SITE DEVELOPMENT PLANS FOR SLIM CHICKEN'S FALCON MARKETPLACE LOT 9

A PARCEL OF LAND LOCATED IN A PORTION OF THE SOUTHEAST QUARTER OF SECTION 1,
TOWNSHIP 13 SOUTH, RANGE 65 WEST OF THE SIXTH PRINCIPAL MERIDIAN,
COUNTY OF EL PASO, STATE OF COLORADO
PCD FILE #PPR-21-026

SITE DEVELOPMENT PLANS

DESCRIPTION
1ST SDP SUBMITTAL
2ND SDP SUBMITTAL

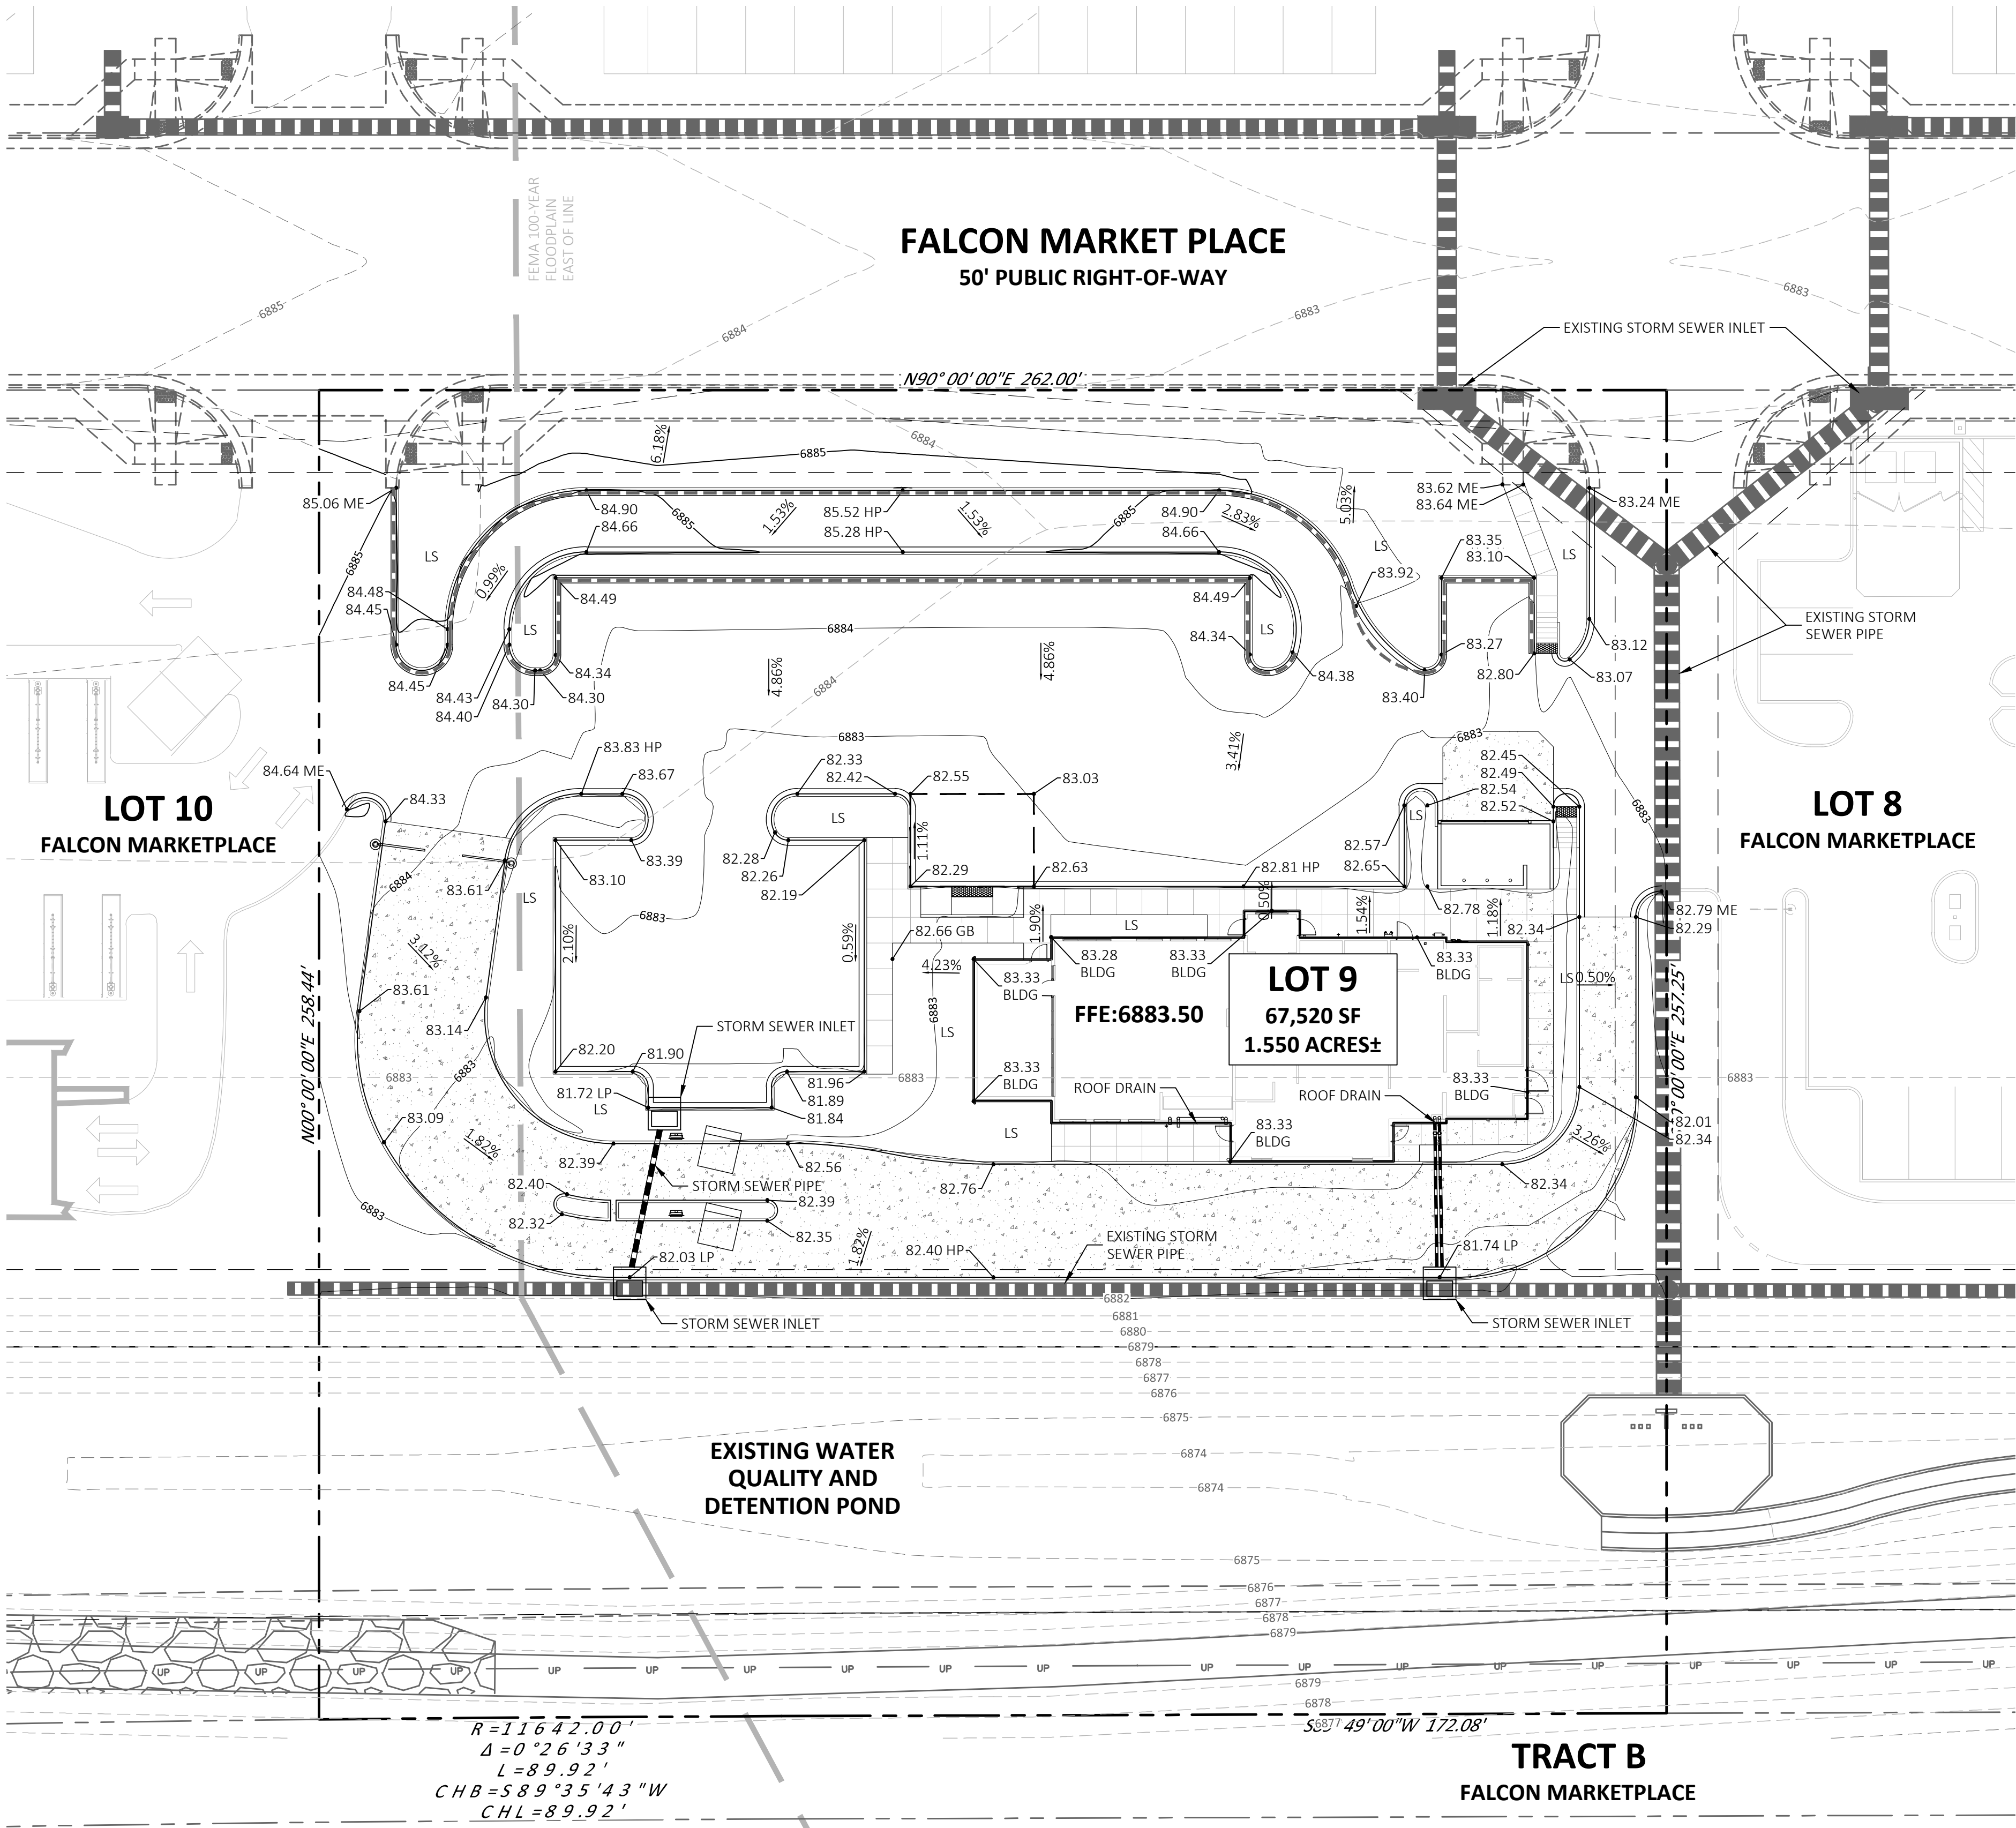
4,023 sq. ft. would result in 40 parking spaces required per LDC Table 6-2 which requires 1 space per 100 sq. ft fast food drive thru use.

Please ensure proper counting for parking spaces. I counted 39 spaces, including the ADA spaces. ADA spaces can count toward total number. You need 40 spaces to meet the LDC requirements.

An Alternative Parking Request has been submitted.
